17th May 2021

Application No: AB/49/21/PL
Site Address: Old Bank House 1 High Street Arundel BN18 9AD
Description of works: Replacement of all windows with new timber double glazed sliding box sash windows and the proposed rendering of the South Elevation (front) and the West Elevation (side) with render painted white. This application may affect the setting of a Listed Building and affects the character and appearance of the Arundel Conservation area.

OWPC36277

ARUN DISTRICT COUNCIL AB/49/21/PL

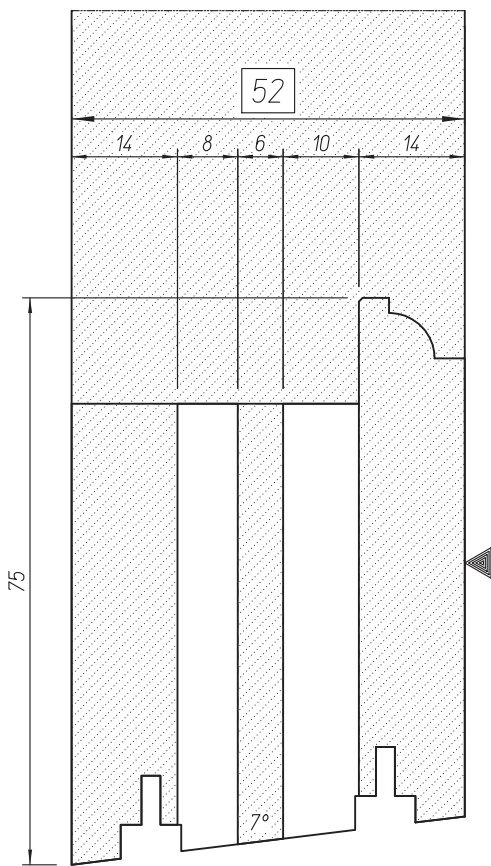
The Committee objected to the application on the grounds of affecting the street scene and that the windows should be in the original style using secondary glazing rather than using replacement double glazing.
